The Planning Inspectorate Yr Arolygiaeth Gynllunio

Application by AQUIND Ltd for the AQUIND Interconnector

The Examining Authority's first written questions

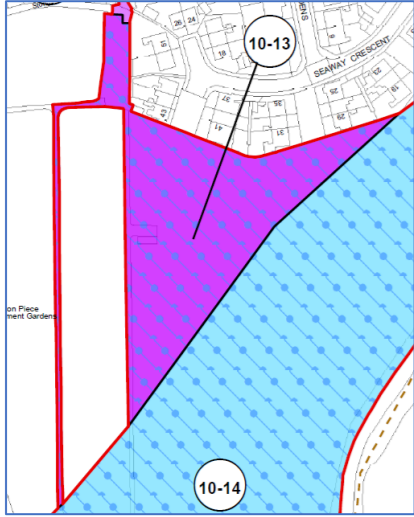
CA1.3.22	The Applicant	<p>Why is, what appears to be, the grass track within the Milton Piece Allotment Gardens included within the Order limits when other accesses would appear to be available within other parts of Plot 10-13 (Land Plans Sheet 10 of 10 Plot 10-13 [APP-008])?</p>

Plate 1 - Plots 3-12 and 3-13 as shown on Land Plan as at Application

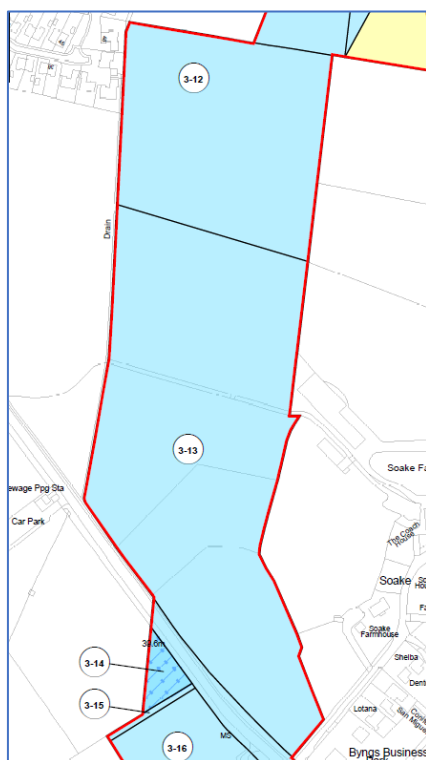
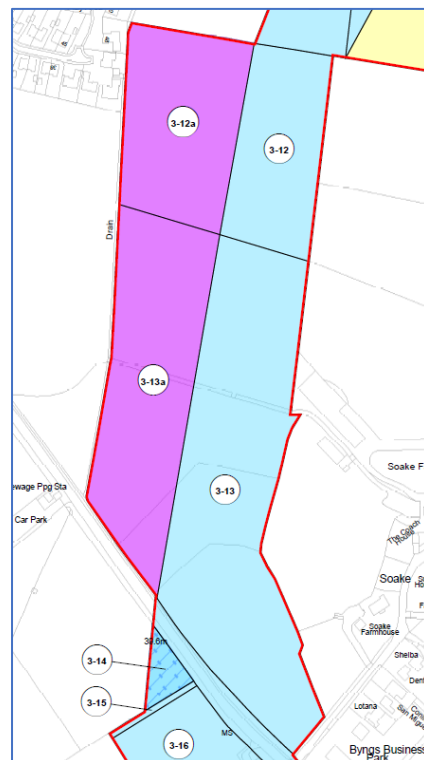
Reference	Respondent(s)	Question
		At what point during the Examination will information be available to the ExA to confirm the 'option' that is being taken forward in the dDCO?
CA1.3.7	The Applicant	At various junctures on the Lands Plans [APP-008] (for example plot 7-06), there are isolated pockets of land included within the Order limits. Can each of these be explained as to its purpose, need and why it is in the public interest to acquire such land?
CA1.3.8	The Applicant	There is no mention in the Funding Statement [APP-023] of any European grants or funding being allocated to the Proposed Development. Is there a reason for this?
CA1.3.9	The Applicant	Please provide the ExA with a copy of the audited accounts for the previous year said to be available from March 2020 (at paragraph 4.7 of the Funding Statement [APP-023]), together with any update to the funding position following the publication of these accounts.
